**From:** Gylling Consulting, Inc. <gyllingconsulting@fairpoint.net>  
**Sent:** Wednesday, May 25, 2016 6:30 PM  
**To:** Jeff Watson  
**Cc:** clellum2003@msn.com; ljcat37@gmail.com; mbaker@sbwconsulting.com; judy@tobinbaker.net; eric.chipps@soundtransit.org; kristine@ilovewaterfront.net; tom@thamerlinck.com; tyrcramer@romein.com; Patti / Jim Gylling; ben.wildman@comcast.net; 'George C'  
**Subject:** RE: Mitchell (SP-16-00001) short plat notice dated May 18, 2016

This is the HVT Owner's official response to the Mitchell (SP-16-00001) short plat application.

Re: Mitchell Short Platt (County document SP-16-00001)  
HVTOs Concerns

**MITCHELL SHORT PLAT
PART OF SECTION 31, T. 20 N., R. 17 E., W.M.
KITITIAS COUNTY, WASHINGTON**

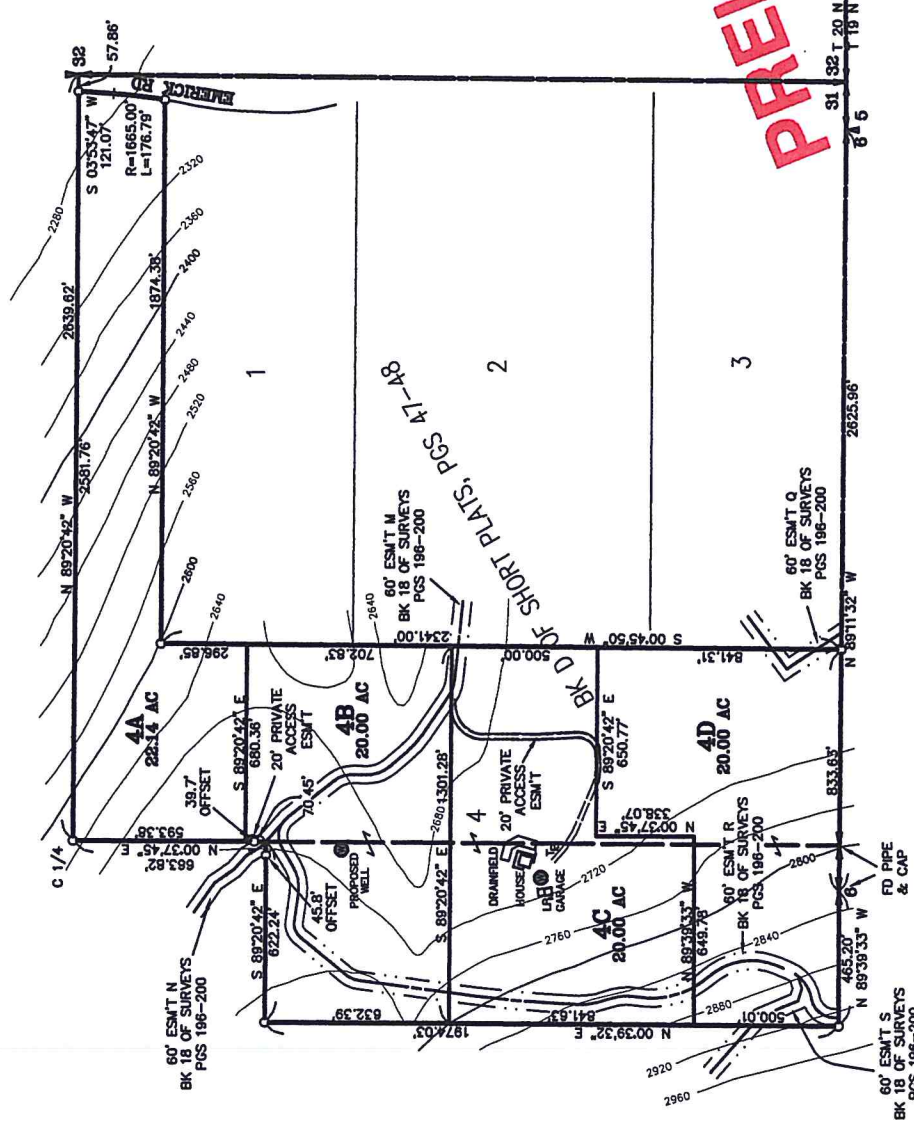
5. Short plat Lot size. Concern has been voiced about the apparent desire to maximize profit vs a more realistic approach to "space". The HVTOs would ask that you reconsider four lots, sized at the 20 acre minimum, and match the short plat lot sizes better with the existing land features- three lots seem to fit the area better, considering the following:

- a. The Critical Areas Checklist in the short plat application erroneously states that the subject property does not contain a wetland:  
<http://www.co.kittitas.wa.us/uploads/cds/land-use/Short%20Plats/SP-16-00001%20Mitchell/SP-16-00001%20Mitchell%20Critical%20Areas%20Checklist.pdf>  
Both Washington statute and the Kittitas County Code define a "wetland" as follows:  
"Wetland" or "wetlands" means areas that are inundated or saturated by surface water or groundwater at a frequency and duration sufficient to support, and that under normal circumstances do support, a prevalence of vegetation typically adapted for life in saturated soil conditions."  
RCW 36.70A.030 (21); Kittitas County Code 17A.02.310.

The seasonal ponds on proposed Lot 4B and 4D has cattails and other vegetation that can't survive without occasional inundation by water. The pond also is the home to many frogs, and it frequented by deer, elk, wildlife and ducks.

Kittitas County Code 17A.04.020 says that wetland buffers should be 50 to 200 feet from the edge of the wetland. Because the wetland on proposed lot 4B and 4D gets regular visits by animals that might be spooked to have a house built nearby, you should agree that the buffer will be 200 feet. A 200-foot buffer would still leave several potential building sites on both proposed Lots 4B and 4D. Reducing the total number of lots from four to three would help increase the building areas.

- b. Water availability. One never knows the impact of "more straws in the drink", but drilling a class B well may have an effect on the other wells in the area. This is always a concern and the additional family units could have a detrimental impact to existing wells. Our wells produce relatively low quantities (gpm) now, we hope the addition of a larger class B well will not have an adverse impact.

- e. Road access. The assumption is all access to your re-platting would be from the existing easement M, then through roads created on your property. The existing deeded covenant has definitions of the HVT roads, granted easements and their designated use. Any modifications to this deeded covenant use definition and/or cost sharing requires specific HVTO's prior approval.

- f. Whatever the final outcome on re-platted lot sizing and quantities, concern exists regarding sight-lines and encroachment of existing open areas. This can be mitigated by larger lot sizing, but also through setbacks and offsets. We know you understand the many requirements of offsets from septic and water source(s). This all factors into the usable and buildable areas within a lot.
